EL PASO COUNTY GRADING AND EROSION CONTROL PLAN CHECKLIST

EPC Project Number: **PPR2417**

C1.2 MVE PROJECT 61195
MVE DRAWING GEC-GP

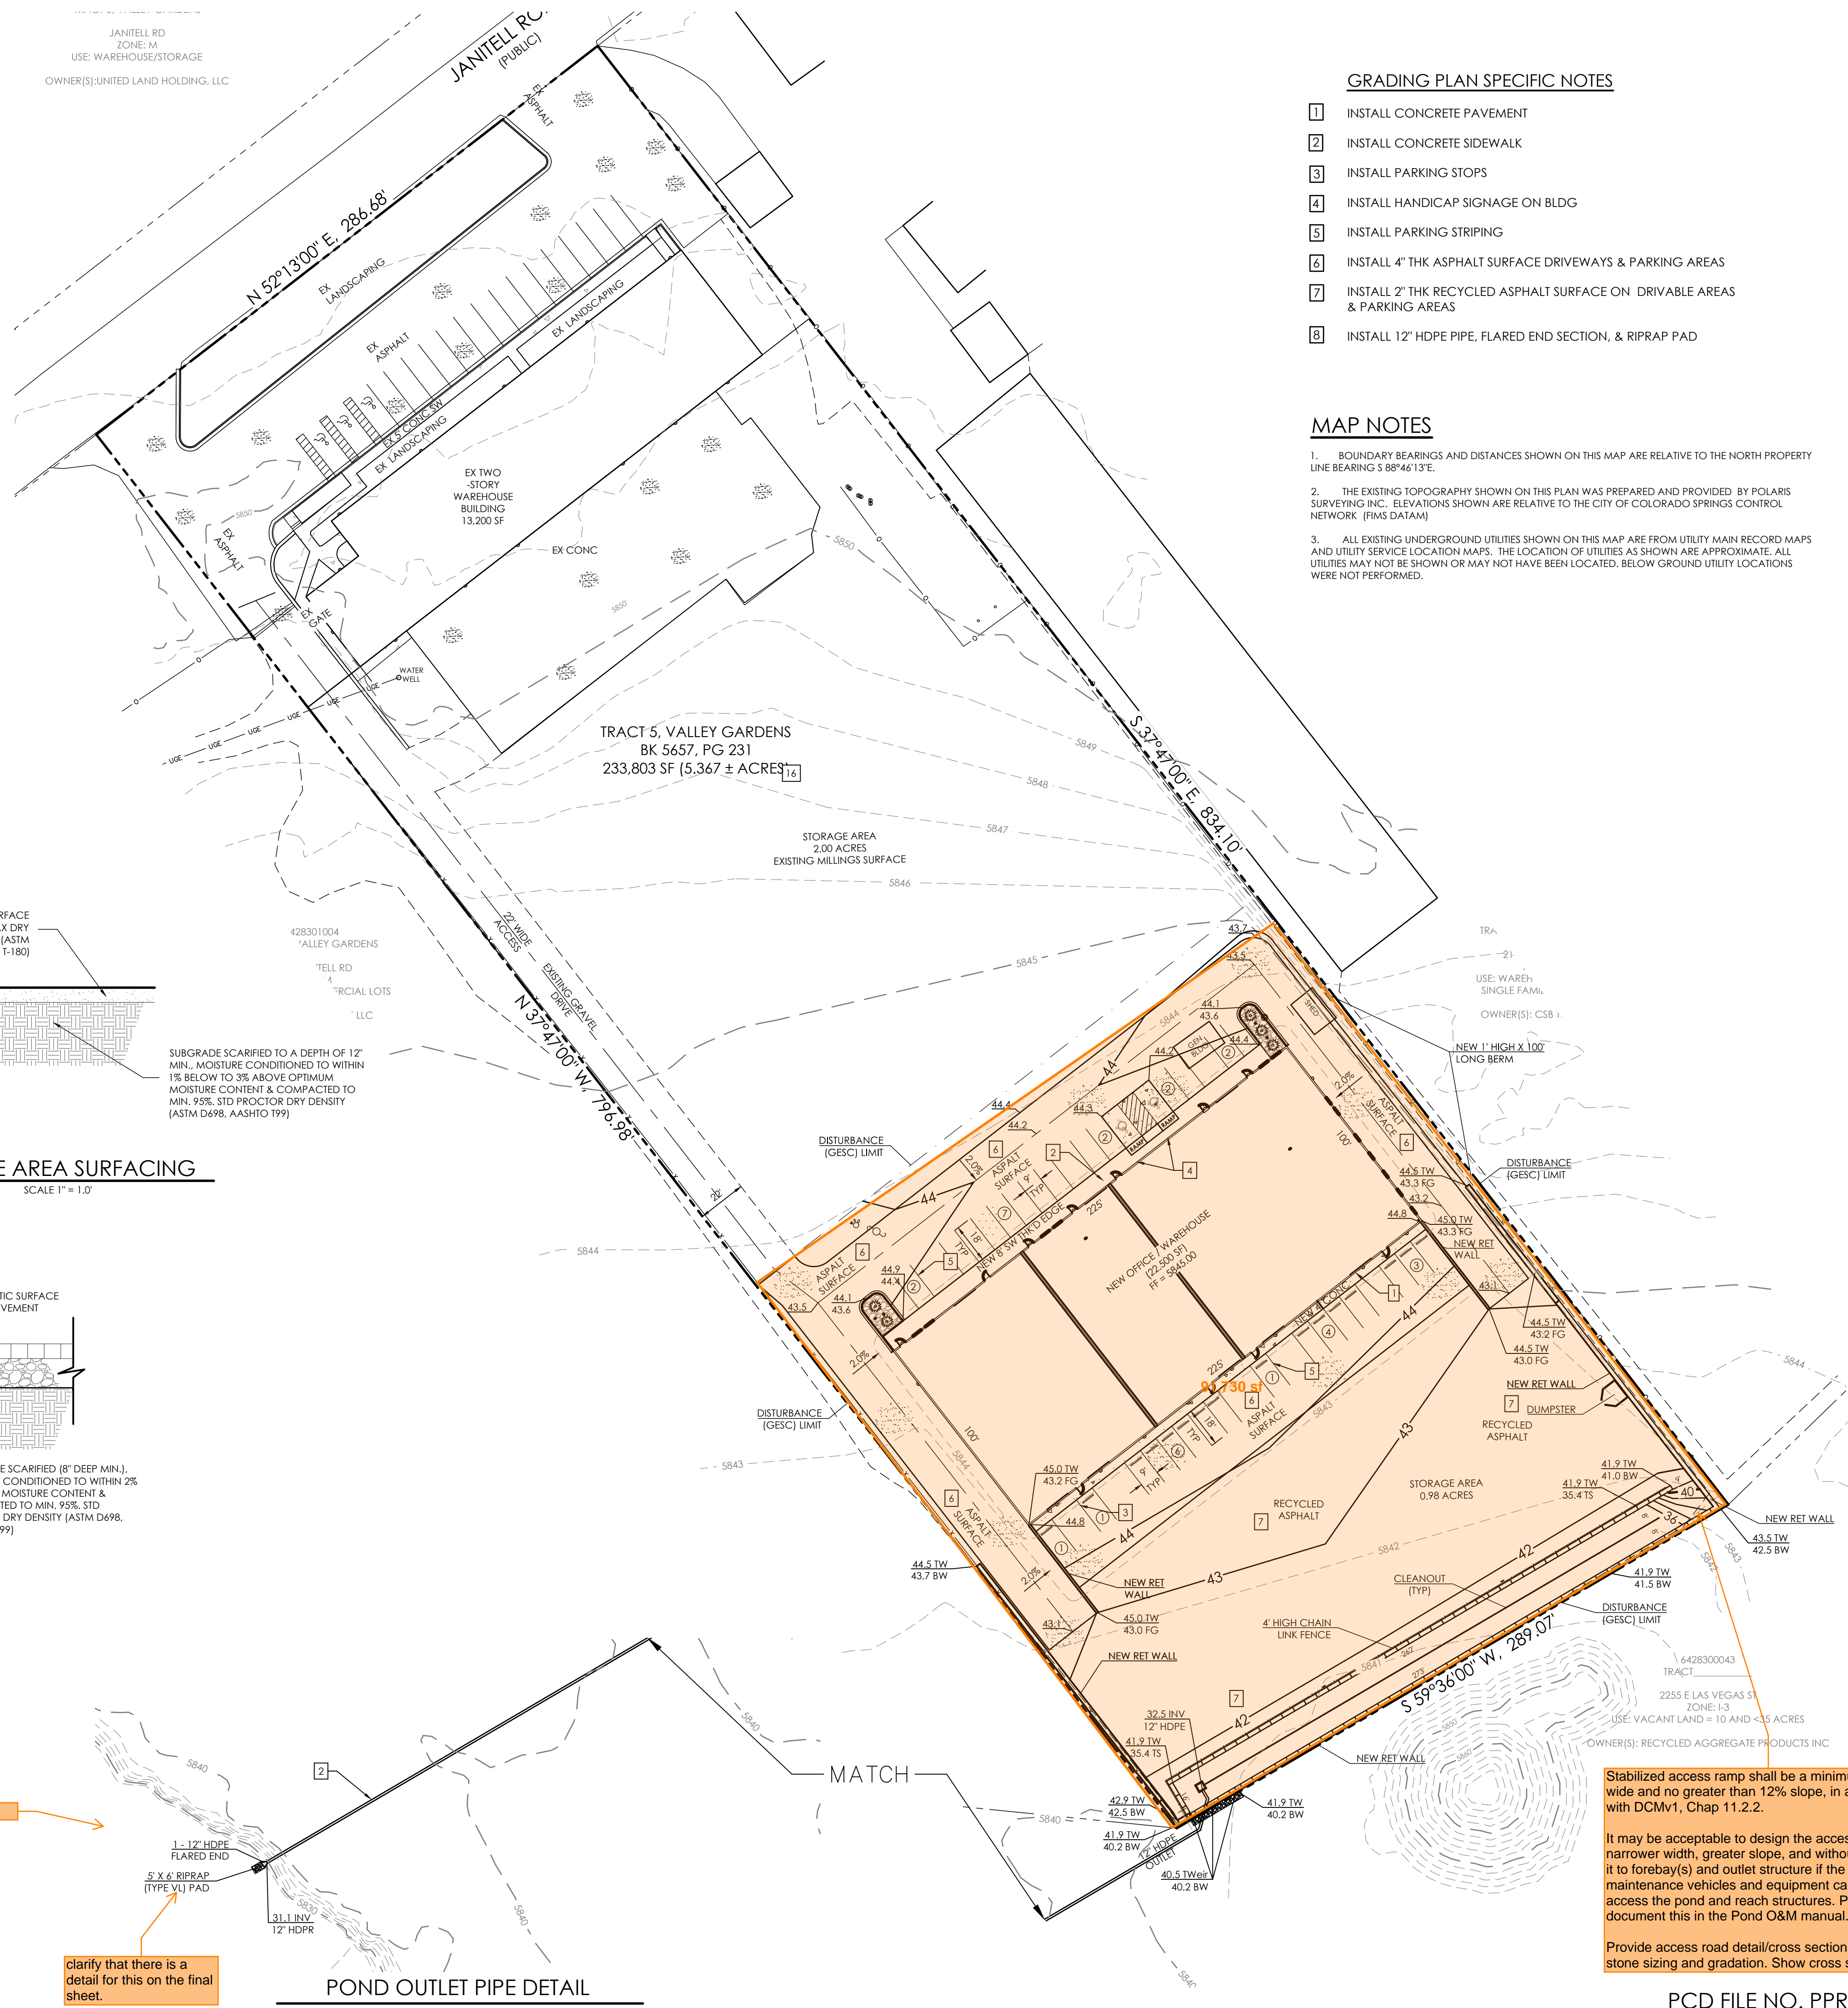
revise to "x" since the SFB and Fountain Creek are shown on plan.

| | | Applicant | EPC |
|--|--|-----------|-----|
| o | Off-site grading clearly shown and called out Revise to "x" and clearly label on plans. | | N |
| s | Stormwater flow direction arrows provide more around the site | | N |

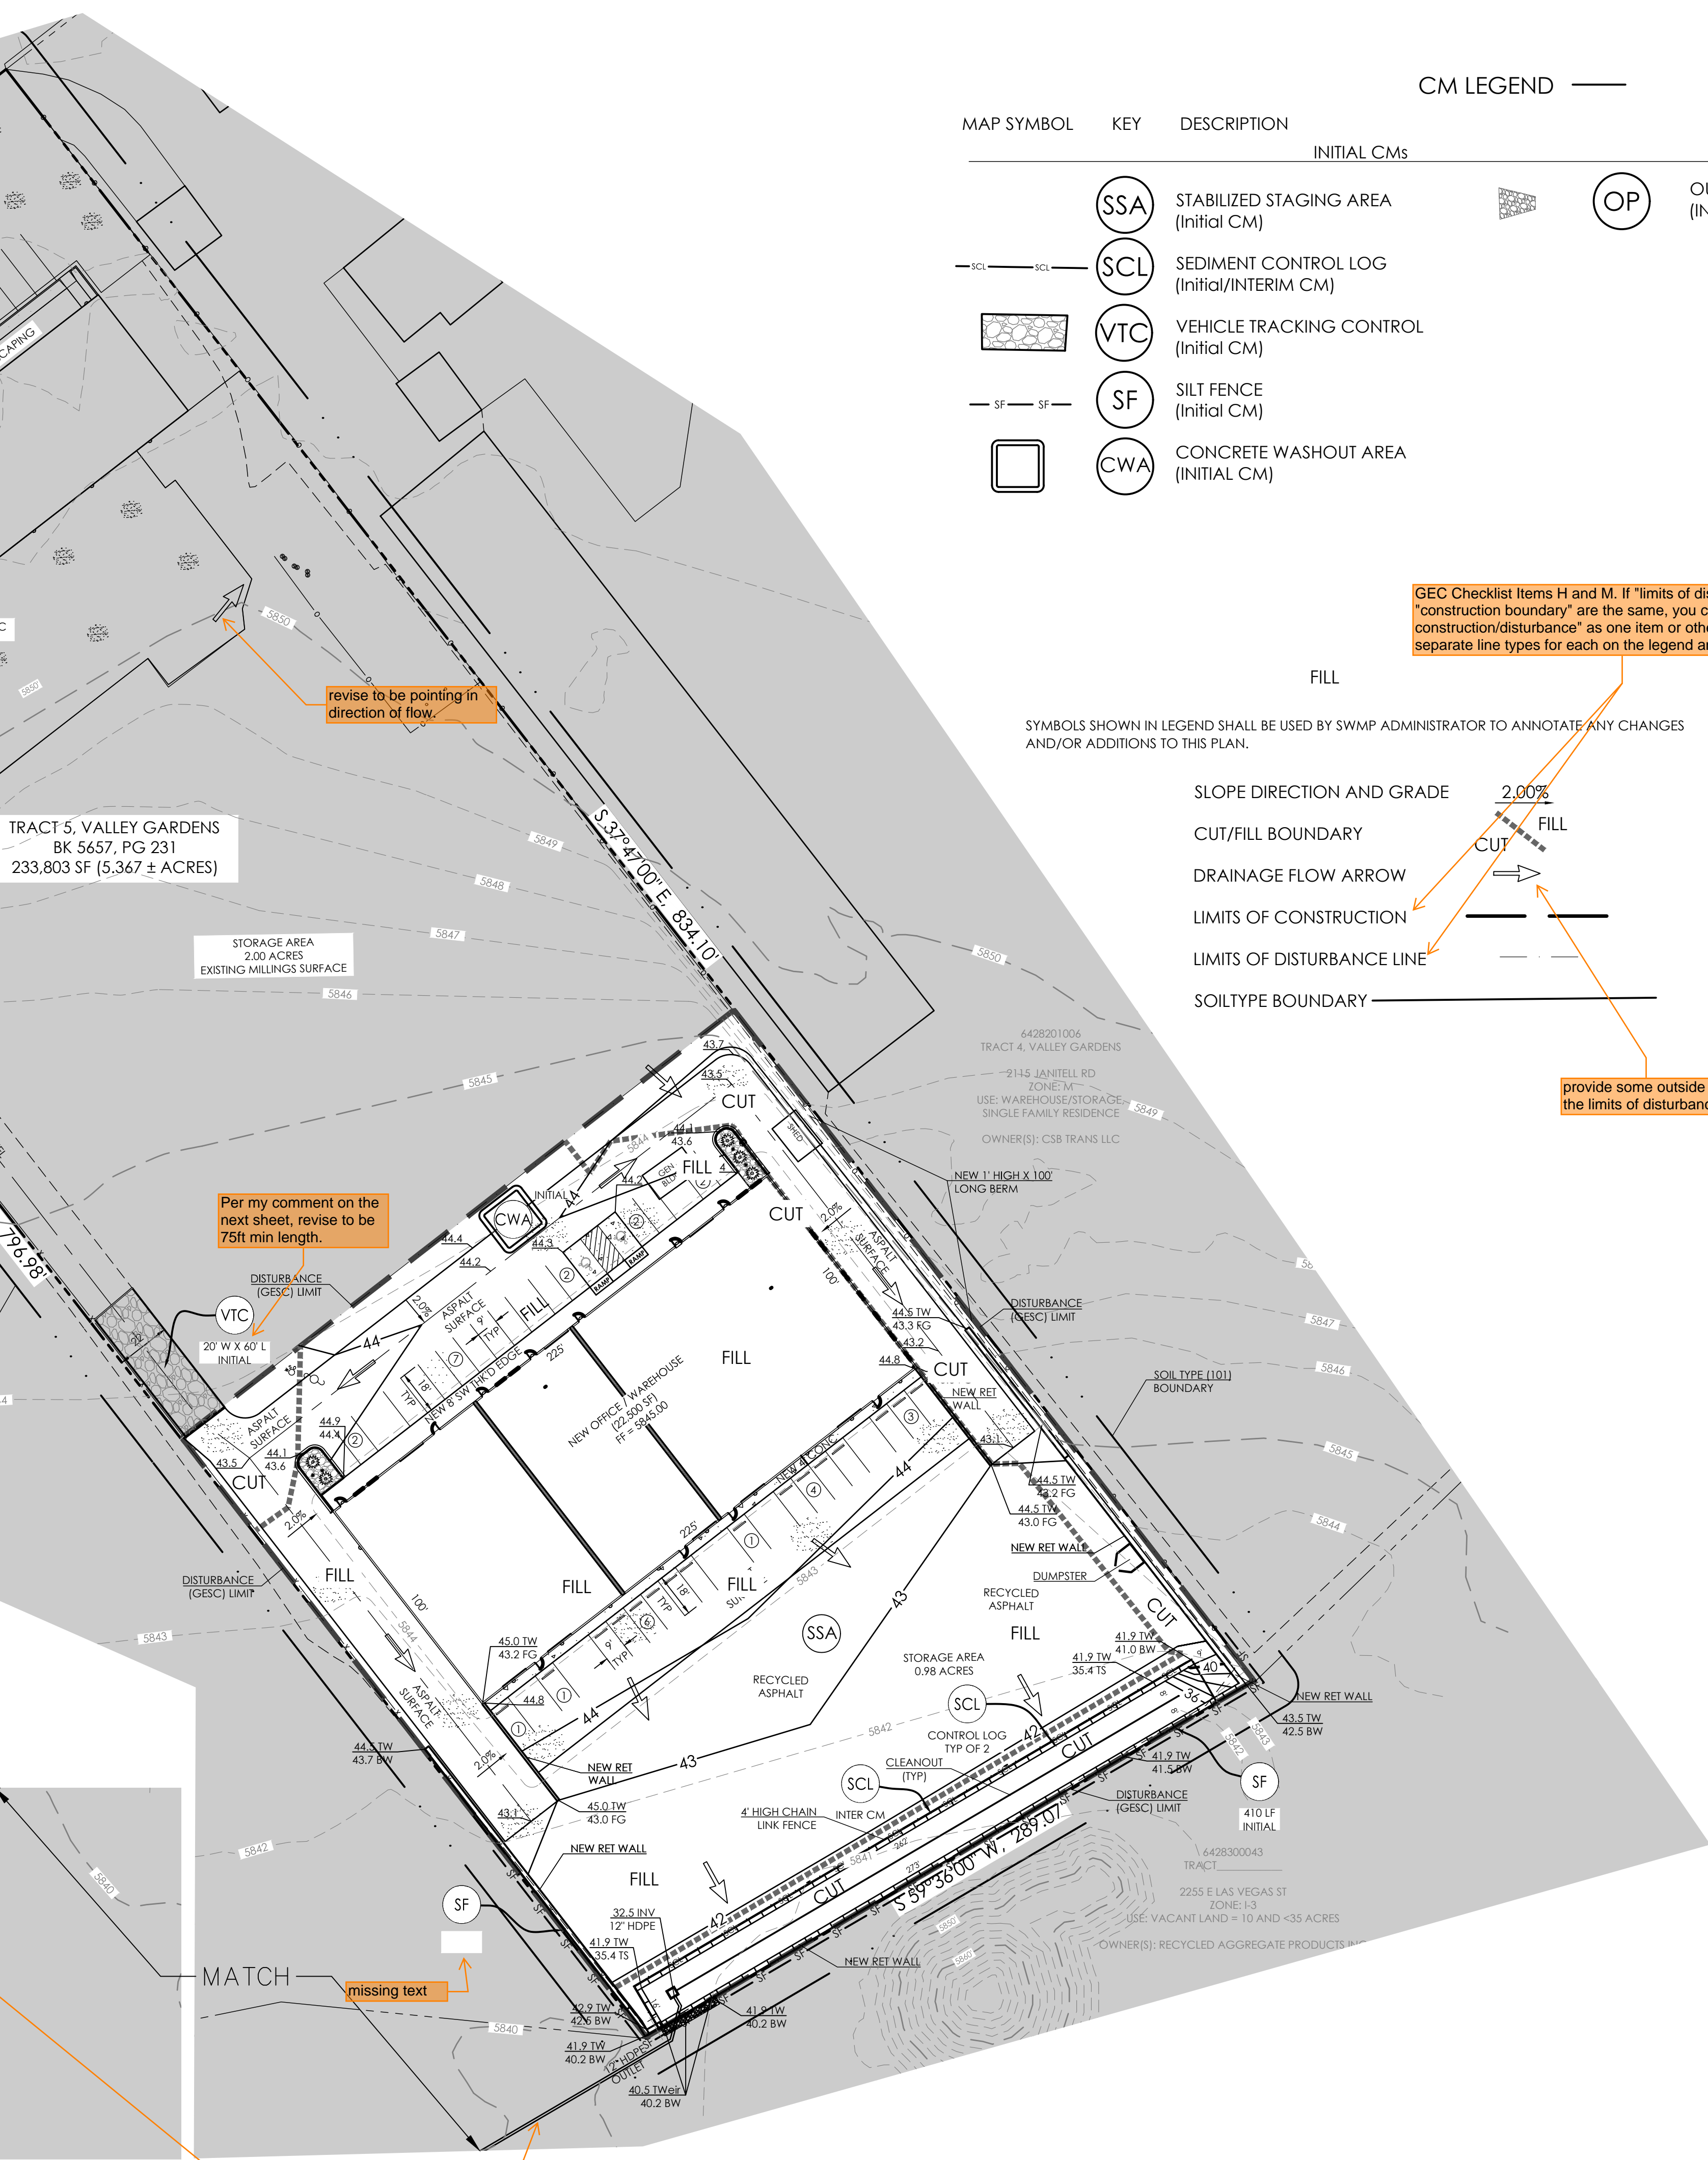
| | | Applicant | EPC |
|--|--|-----------|-----|
| i | Existing vegetation (notes are acceptable in cases where there is no notable vegetation, only grasses/weeds, or site has already been stripped) clarify your note on the plans | | N |
